Application for a Non-Material Amendment Following a Grant of Planning Permission

Site to southern end of Salt Box field, defined as 'Unit 9' within larger hybrid application

BE/135/18/PL

Non-Material Amendment(s) Sought

Client	Richmond Motor Group
Project	Salt Box Site, Bognor Regis
Title	Proposed Elevations

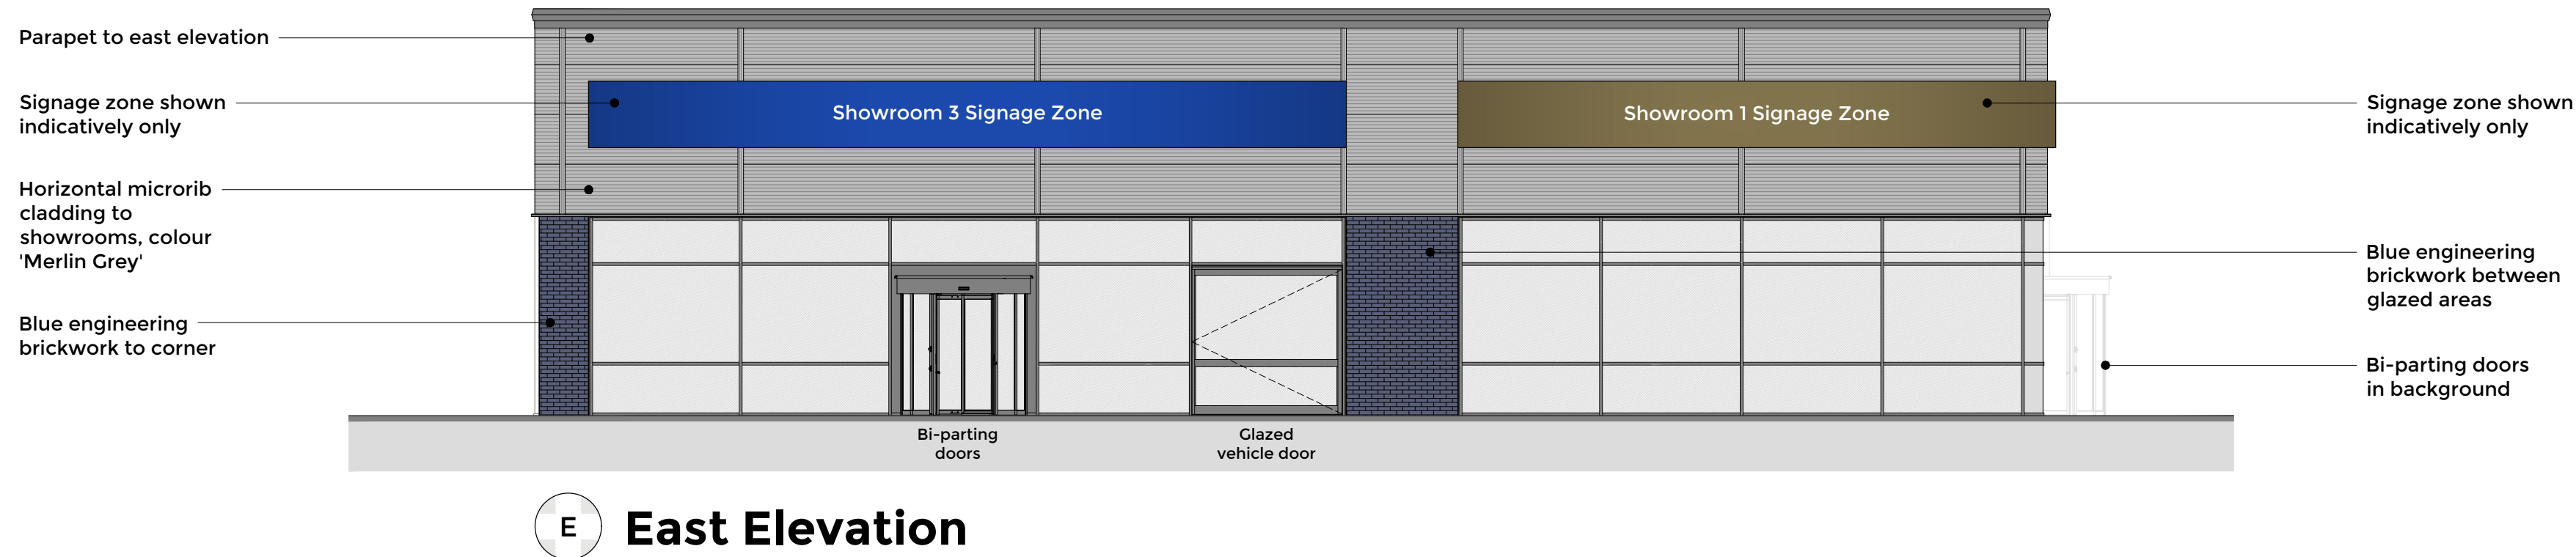
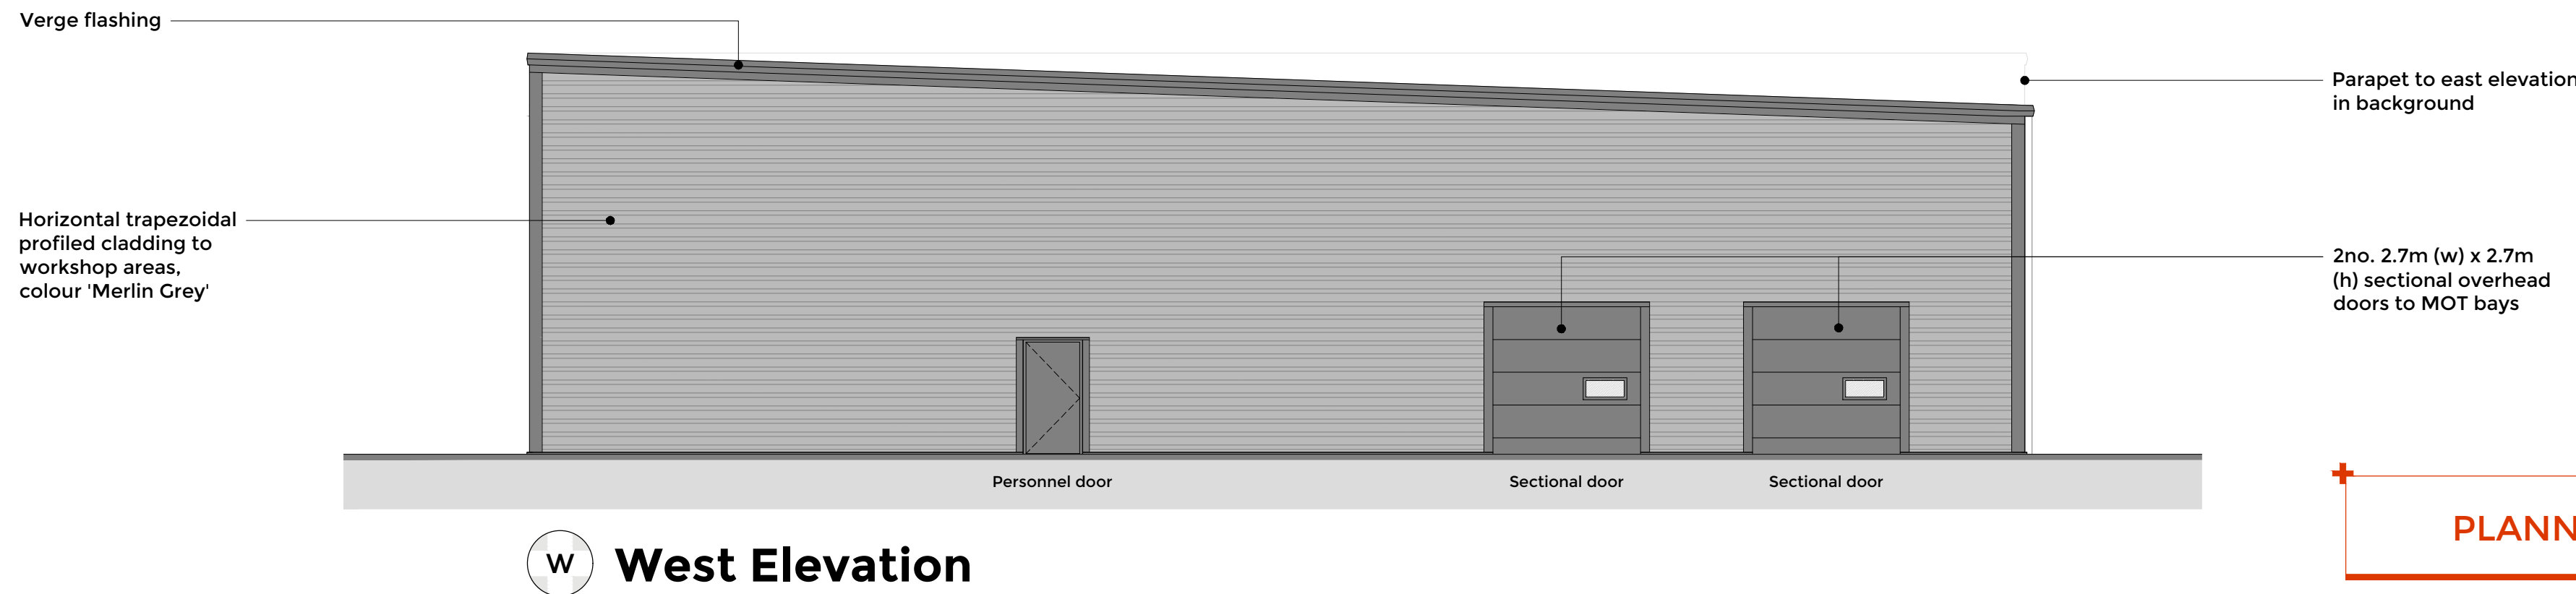
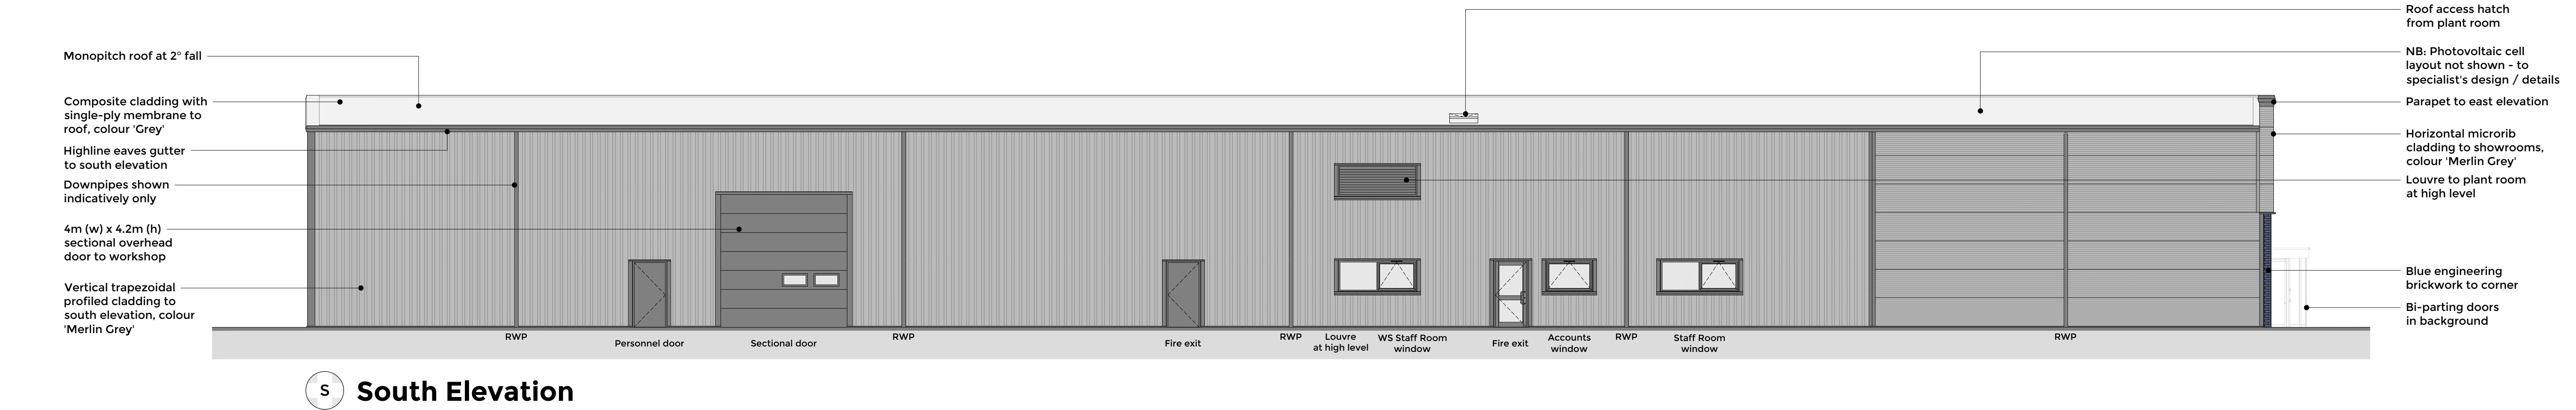
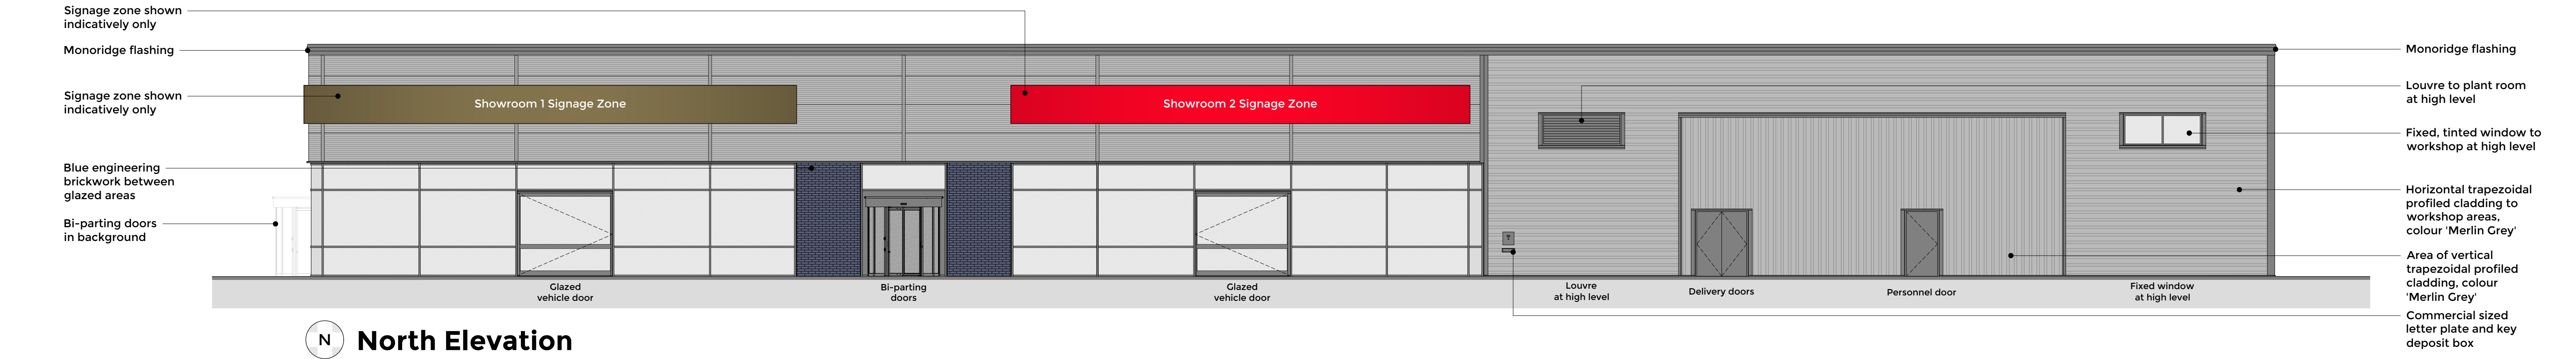
- Building depth reduced by c. 3.5m
- Roof profile changed - now monopitch rather than portal frame
- Roof material amended (now single ply to suit low pitch roof) and rooflights omitted
- Vertical cladding shown to south elevation
- Additional fire exit door shown to south elevation
- 3no. revolving and 3no. accessible doors to showrooms omitted and replaced with 2no. bi-parting 'drum' doors
- Curtain walling layout updated to reflect the above
- 1no. high-level fixed window (north elevation) changed to louvre serving workshop
- Louvre shown to plant room (south elevation)
- Internal layout amended to client's requirements; remainder of mezzanine now shown as expansion space
- Dry Valet and Wet Valet buildings combined; vertical cladding shown to south elevation
- External areas updated to suit

- Adjustment of frame profile made through design development - does not change east elevation, and change to north elevation is minimal (eaves line to workshop slightly higher than previously)

- Roofing material changed to suit low-pitch roof
- 3no. revolving and 3no. accessible doors to showrooms omitted and replaced with 2no. bi-parting 'drum' doors, achieving the required access and means of escape while allowing the layout to be rationalised. Curtain walling elevations now look cleaner and more symmetrical; a larger amount of the blue engineering brickwork between glazing panels has now been provided

- Vertical cladding to south elevation(s) required to achieve fire protection requirements (boundary conditions)
- Additional fire exit door required for Building Control compliance

- 2no. louvres required to suit M&E design
- Valet buildings combined to suit client requirements and also provide better shielding of activities from south of the site

Client	Richmond Motor Group
Project	Salt Box Site, Bognor Regis
Title	Proposed Sections

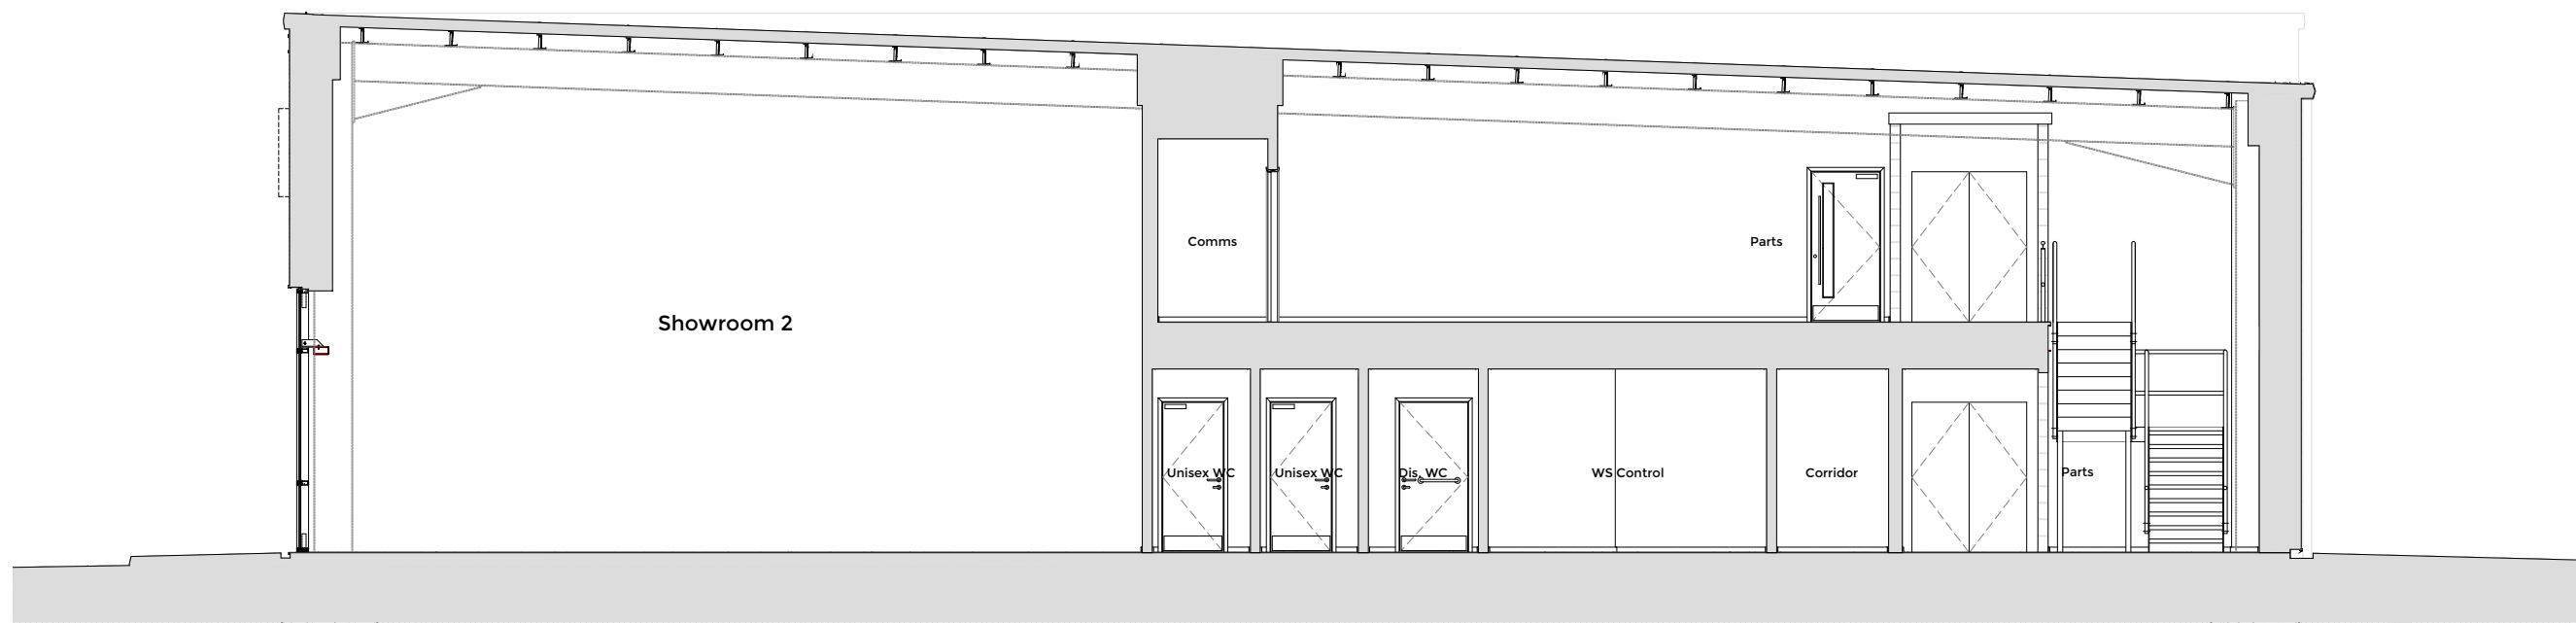
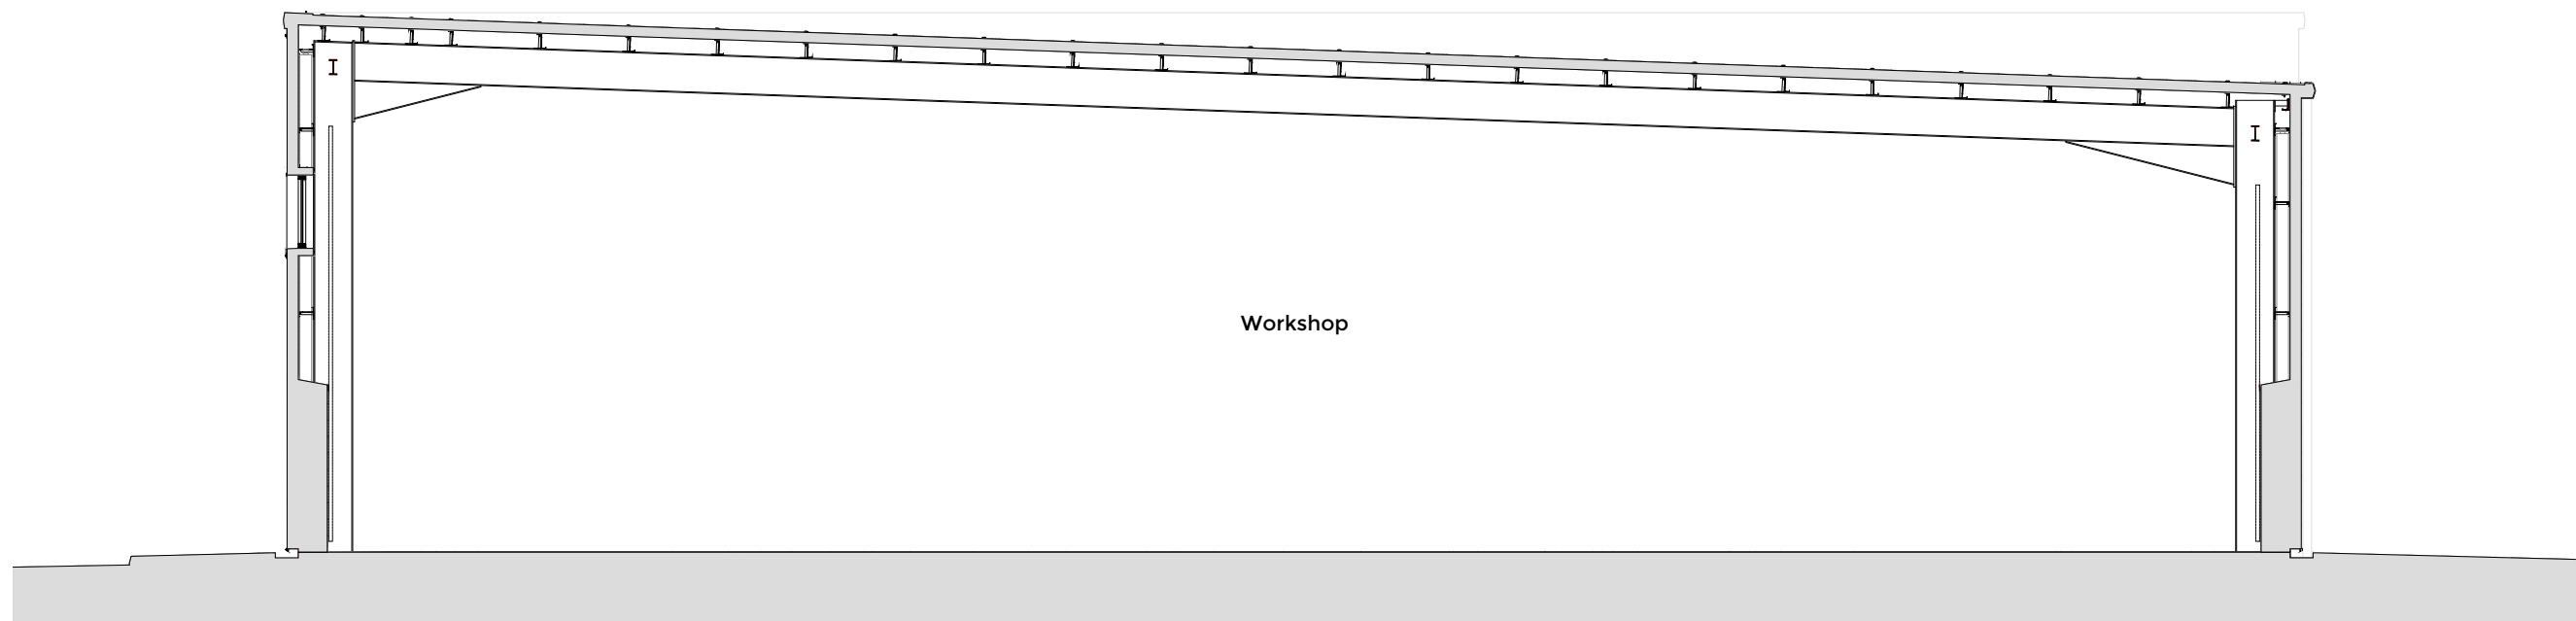
- Building depth reduced and internal layout amended to reflect efficiencies made with remote working, number of staff required on site, etc - majority of first floor is now reserved for potential future expansion
